Application for a non-material amendment following a grant of planning permission.

Erection of ground floor side extension and additional rooflight to first floor

To install a small (frosted) bathroom window to the extension to the front elevation and rather than the proposed rooflight which is positioned above the bathroom.

Non Material Amendment (DRG No Ref NMA 4SW Rev A)

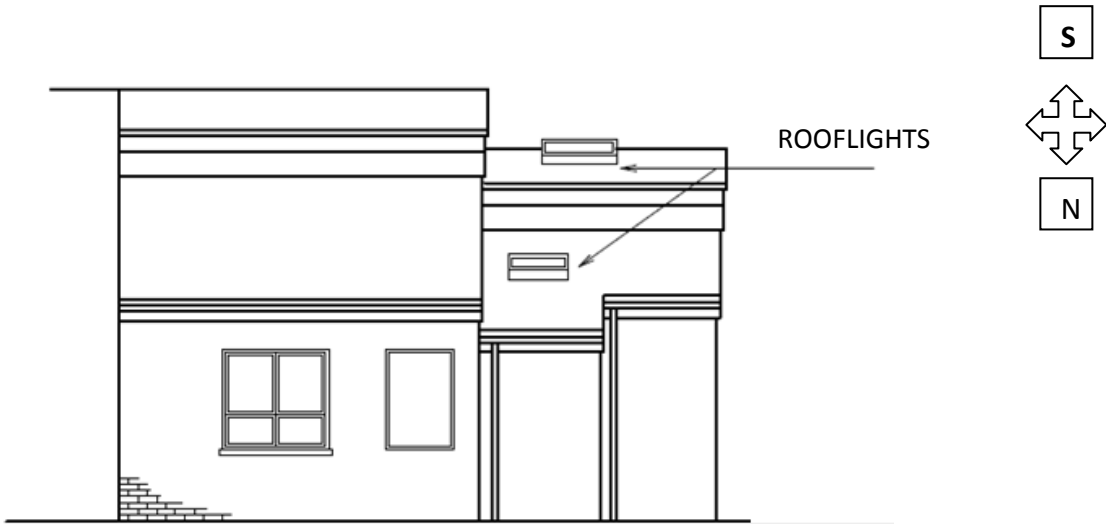
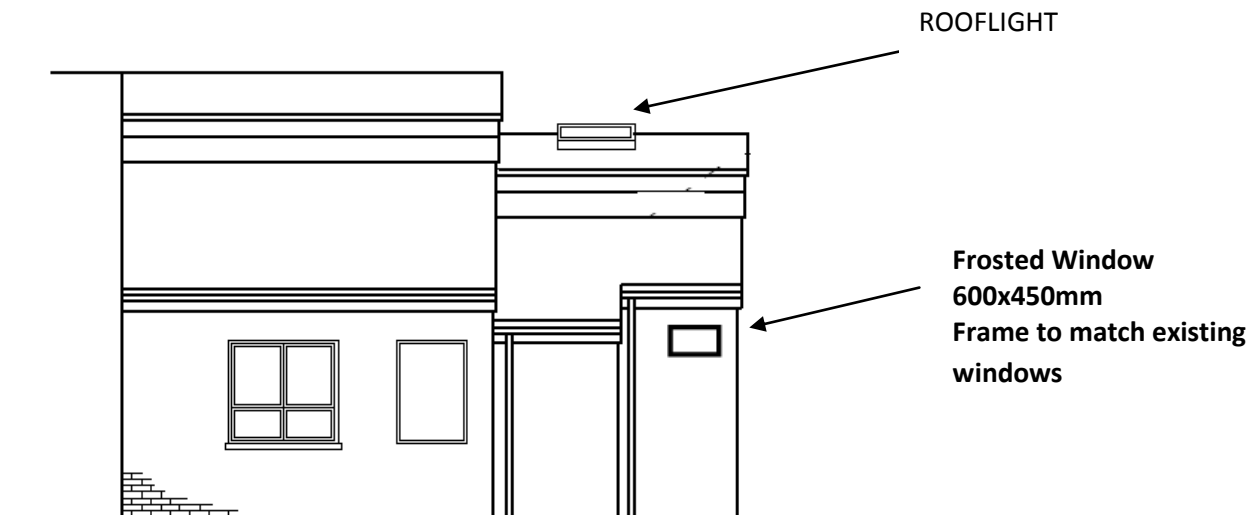
The window would be better suited than a rooflight above the bathroom and would be more in keeping and in line with the look of the existing and other properties. The window will not overlook other properties and will still maintain privacy.
